**KIRKLEES COUNCIL
TOWN AND COUNTRY PLANNING ACT 1990
STREETSCENE & HOUSING
LANDSCAPE SECTION**

PLANNING REF: 2017/94129

PROPOSAL: Demolition of existing buildings and erection of 30 dwellings with associated garages and parking	Ref. No.	FF195
	Officer	EM
	Tel No.	78054/ 07890 630 720
	O.S. Ref.	
LOCATION: Oakroyd Hall, West Yorkshire Fire And Rescue Service Headquarters, Bradford Road, Birkenshaw, BD11 2DY	Date Received	12/12/2017
	Date Returned	08.01.18
	Site Area	1.54 ha

Proposed Layout Plan

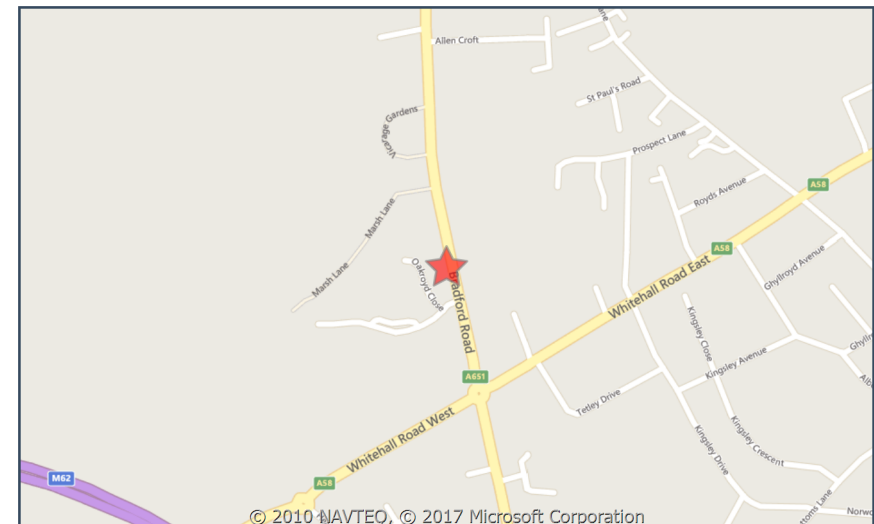
The POS area required for 30no. dwellings is 900 sq.m. The site proposal includes 3 pos areas totalling over 900 sq.m, therefore the onsite amenity open space area is sufficient for this scheme, however the pos for a site of this number of dwellings should be accessible and useable as amenity space for the wider public, within which there should be an equipped play area (a LAP in accordance with 'Fields in trust' Guidelines) although given the setting of the pos on site within the existing trees, this could also be a mixture of some on site provision in terms of natural play and an off-site contribution. In lieu of the full equipped facility being on site (due to the proximity of the protected trees and adjacent housing) we would ask for an offsite contribution towards an existing play facility, to improve the neighbourhood play facility such as at Birkenshaw park which is approximately a 390m walk to the north of the site. A contribution towards the existing facilities there would be considered preferable.

The proposed site plan gives an indicative layout of the development but no details of the hard and soft landscape design of the public open spaces, incorporating the existing protected trees and how they may accommodate accessible amenity use and in particular such as elements of natural play, paths, any seats and litter bins.

Who will manage and maintain the pos in perpetuity? A plan indicating the root protection areas shall need to be provided on the landscape scheme so the impact of the new proposals can be demonstrated in relation to the existing tpo trees and can be identified / addressed.

The existing trees to be retained [as they are protected by TPO's] are shown although there are no detailed landscape proposals to demonstrate the impact within their root protection areas for ensuring accessibility for use of the pos areas. The new landscape proposals both hard and soft need to enhance the existing trees and landscape and take account of the TPO trees. More detailed landscape proposals are required to demonstrate that the landscape scheme for the entire development together with the public open spaces is well designed, accessible, can be well managed and is safe. Planting layout, density and species are key, together with location of footpaths, seats and litterbins.

The scheme will need to demonstrate clearly where bin storage and collection/presentation points are, each dwelling will require 2 no. containers- at least 1 x 240ltr grey & 1 x green 240ltr. Also indicate the location of proposed grit bins. Whilst we understand this is only a sketch layout for the pre-app, It is important that a functional facility for refuse collection is included.

Can the developer please clarify the means of refuse collection for all the properties, for example location of collection points for properties and consideration of the siting of grit bins etc.
